Arun District Council
Arun Civic Centre
Maltravers Road
Littlehampton
West Sussex BN17 5LF
Planning & Building Control General Enquiries
Tel: (01903) 737756 Fax: (01903) 730442
Dx: 57406 Littlehampton
Minicom: 01903 732765
e-mail: planning@arun.gov.uk
website: www.arun.gov.uk/planning

Application No: EP/124/20/HH
Site Address: Little Dormers 23 Upper Drive East Preston BN16 1QN
Description of works: New bay and porch skirt roof to the front elevation, and roof linked detached double garage.

Thank you for your internet representation made on 26th November 2020 which has been recorded as an objection with the comments as follows:

Drawing Name
Elevations-
Proposed

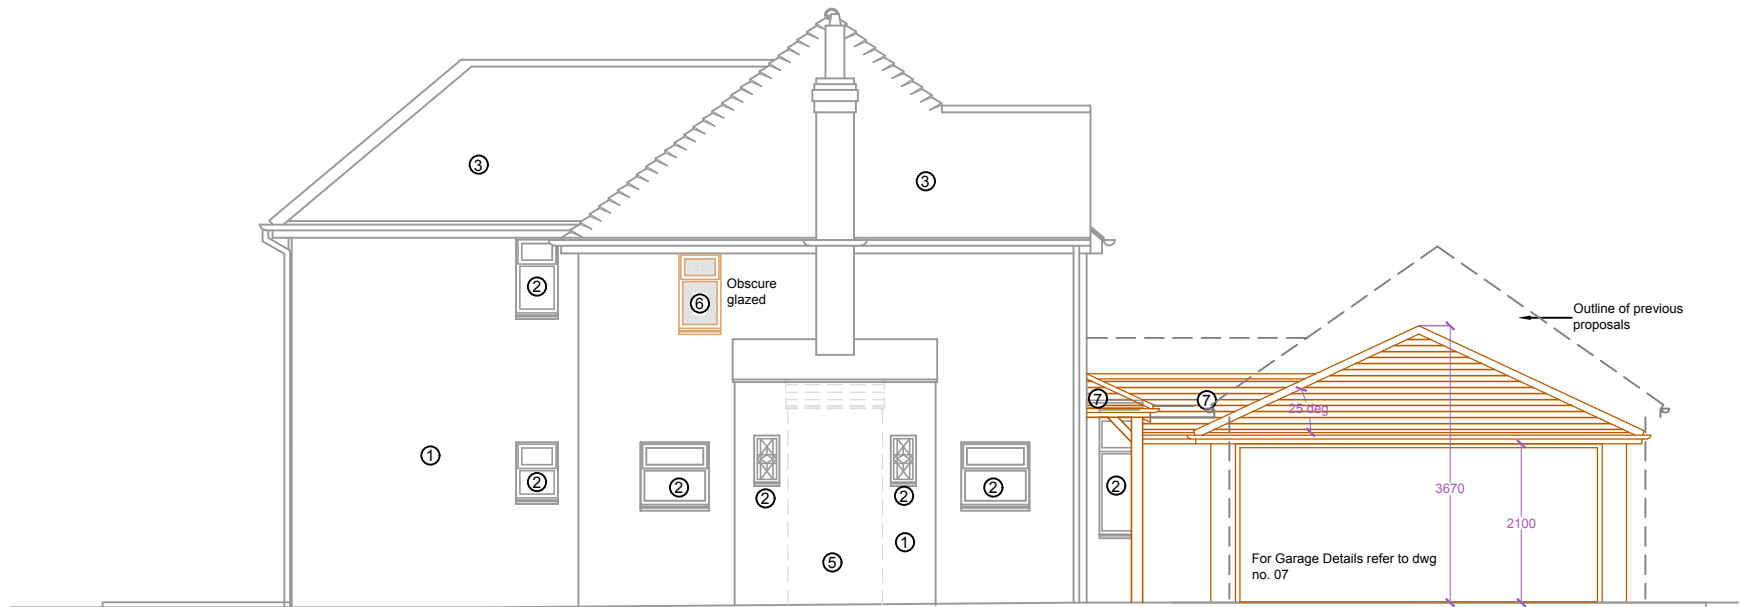
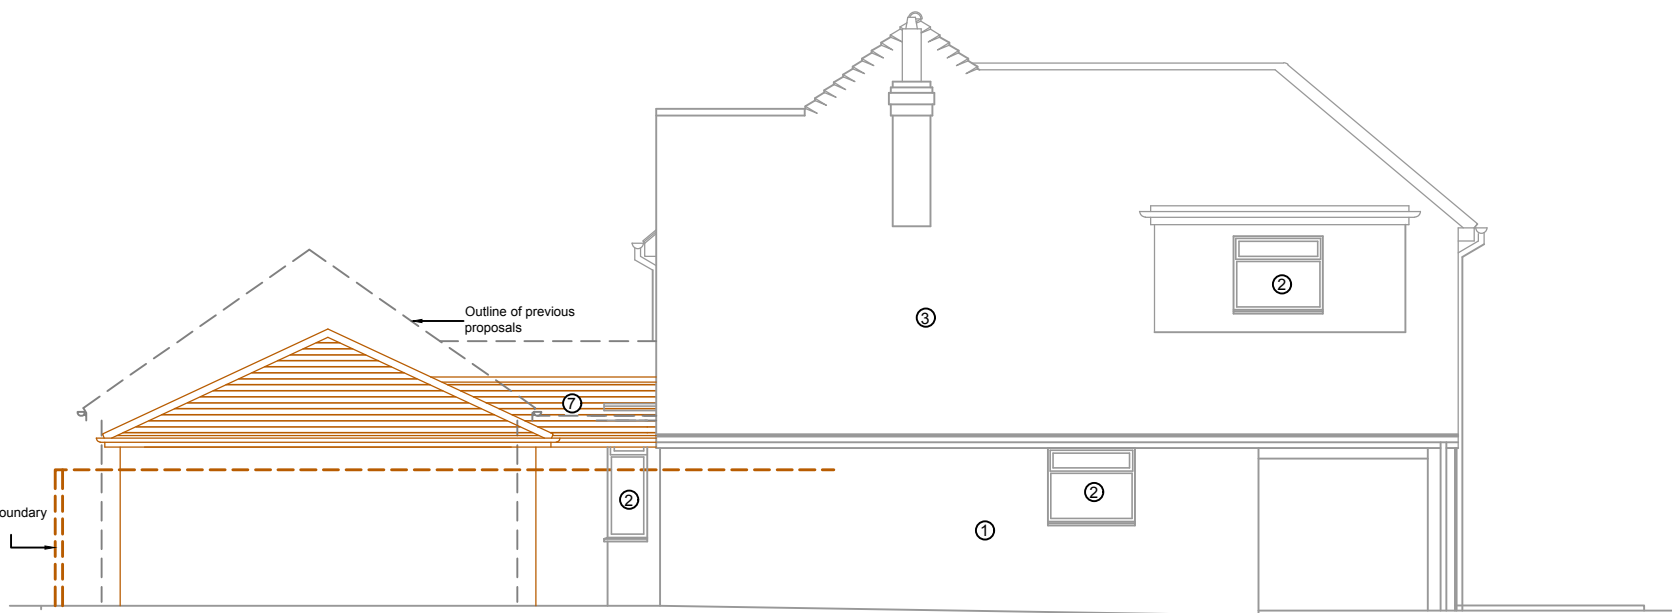
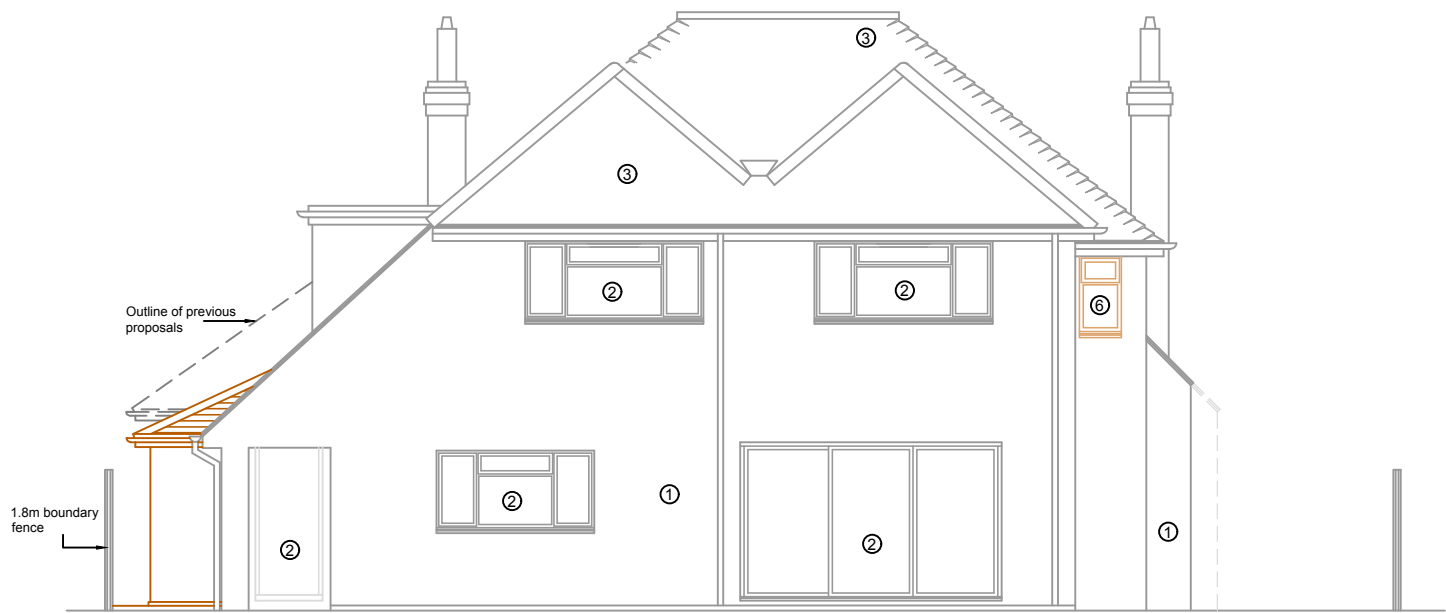
I object to the proposed garage and the first floor windows that overlook the bungalow at 59 Manor Road. Having been present to the applicants presentation to EP Parish Council Planning and Licensing Committee on the 23rd November, I would like to raise the ignored climate crisis issues. Good, healthy trees were cut down to allow for this proposed garage. Although this may seem minor in the grand scheme of the climate crisis, everyone should be doing everything possible to prevent this crisis. This is not a tree preservation area so there was nothing that could be done to stop this.

Garage Plans and Elevations -
Proposed

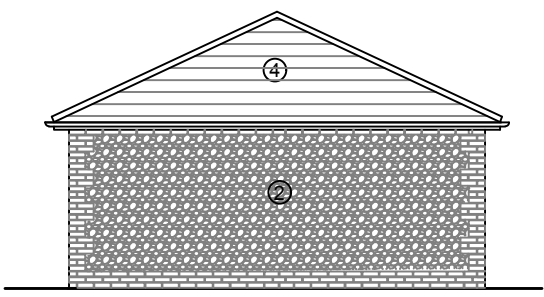
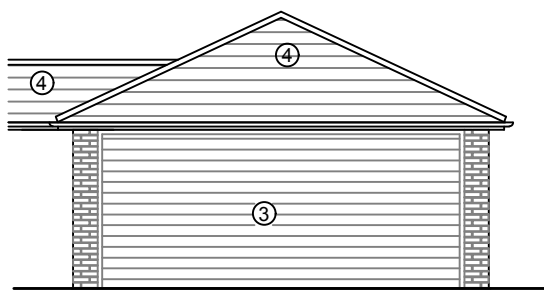
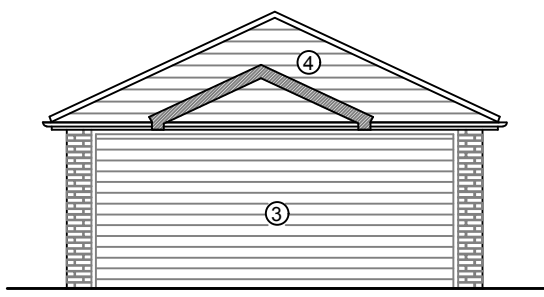
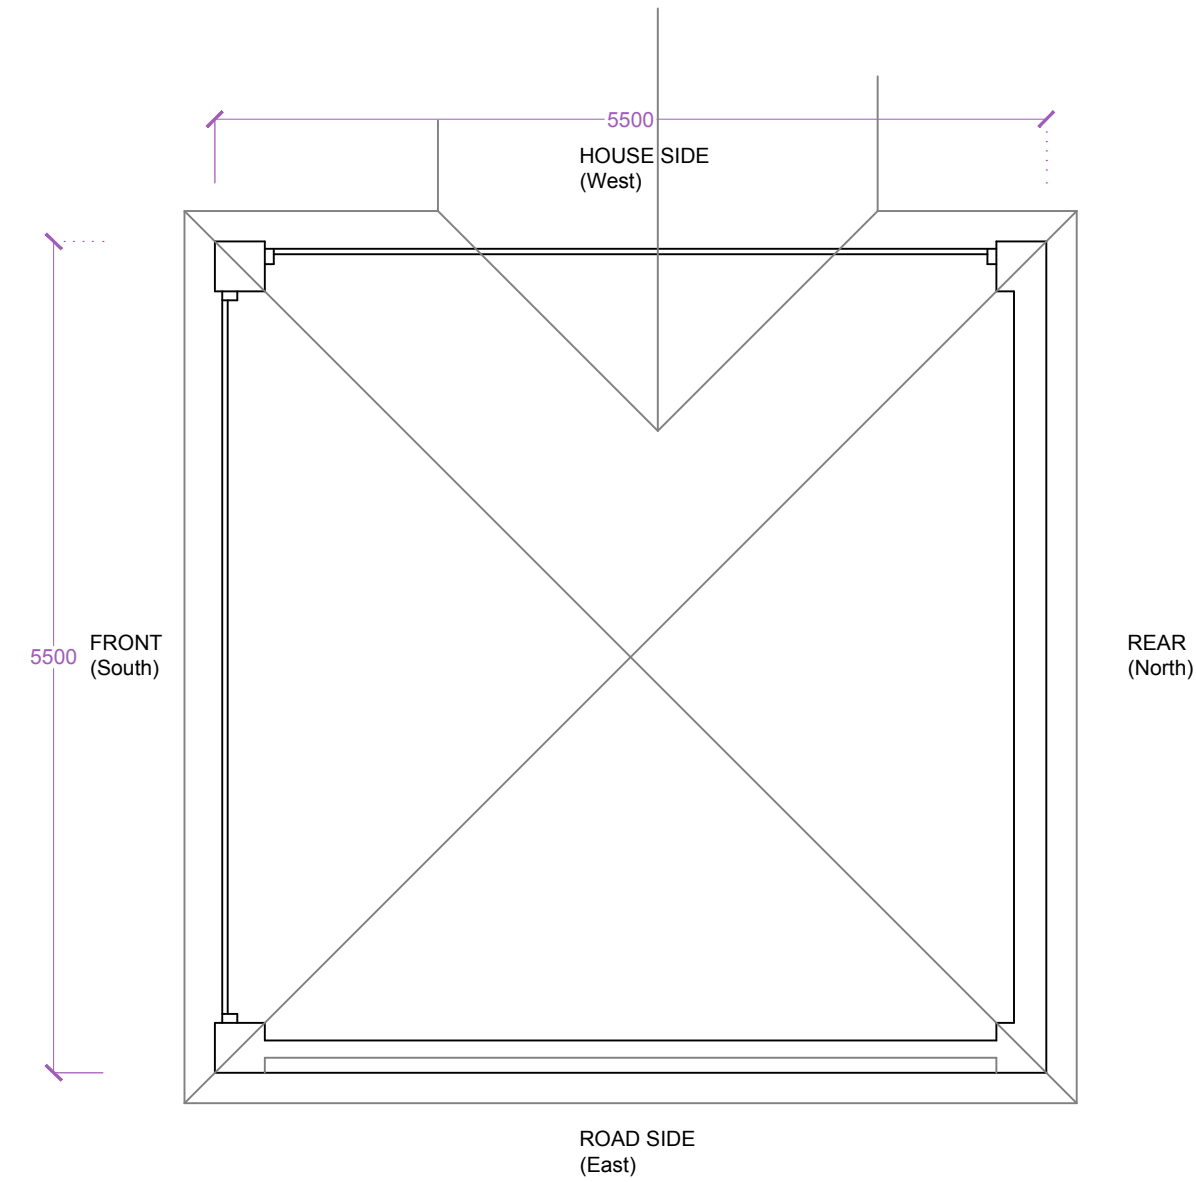
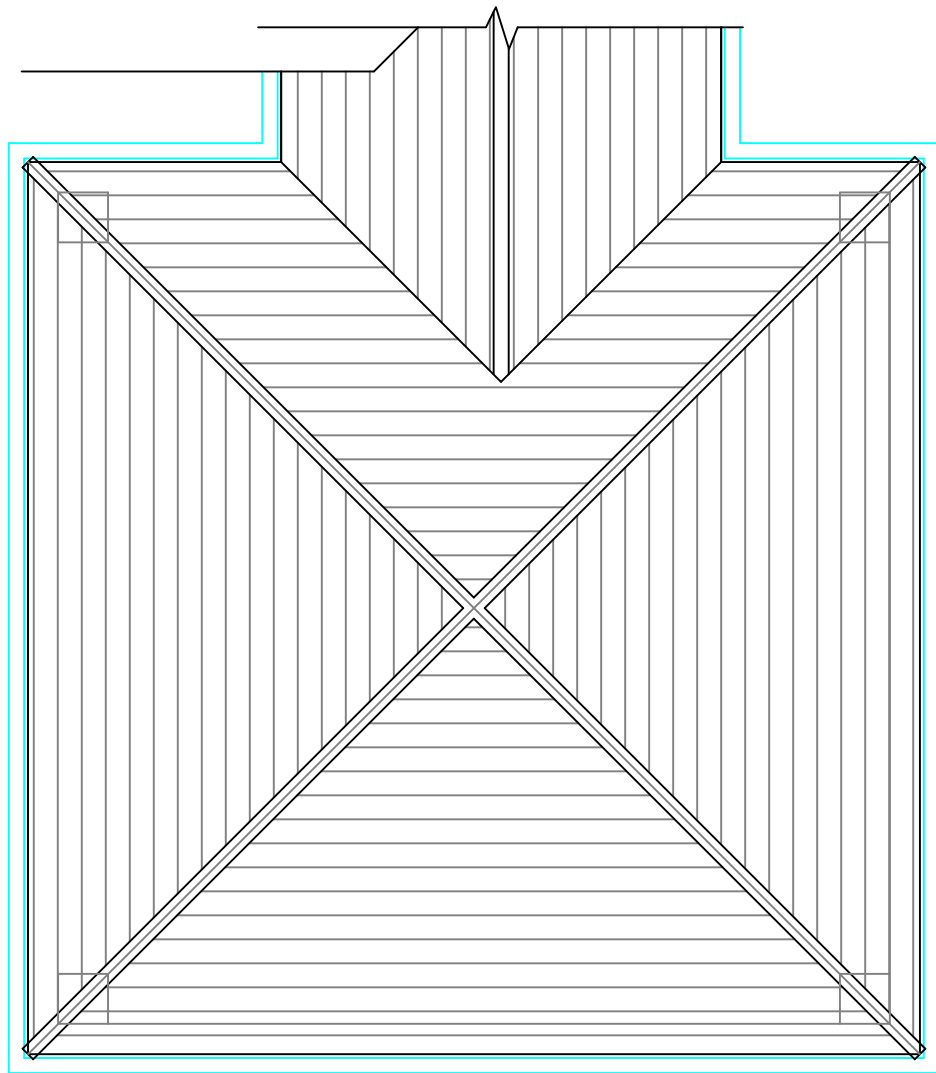
The use of cars like these should be prevented not preserved within a huge structure which will ruin the landscape of the area that is already being destroyed by the emissions from the cars. Furthermore these cars cause significant noise pollution in the local area which affects local wildlife and people.
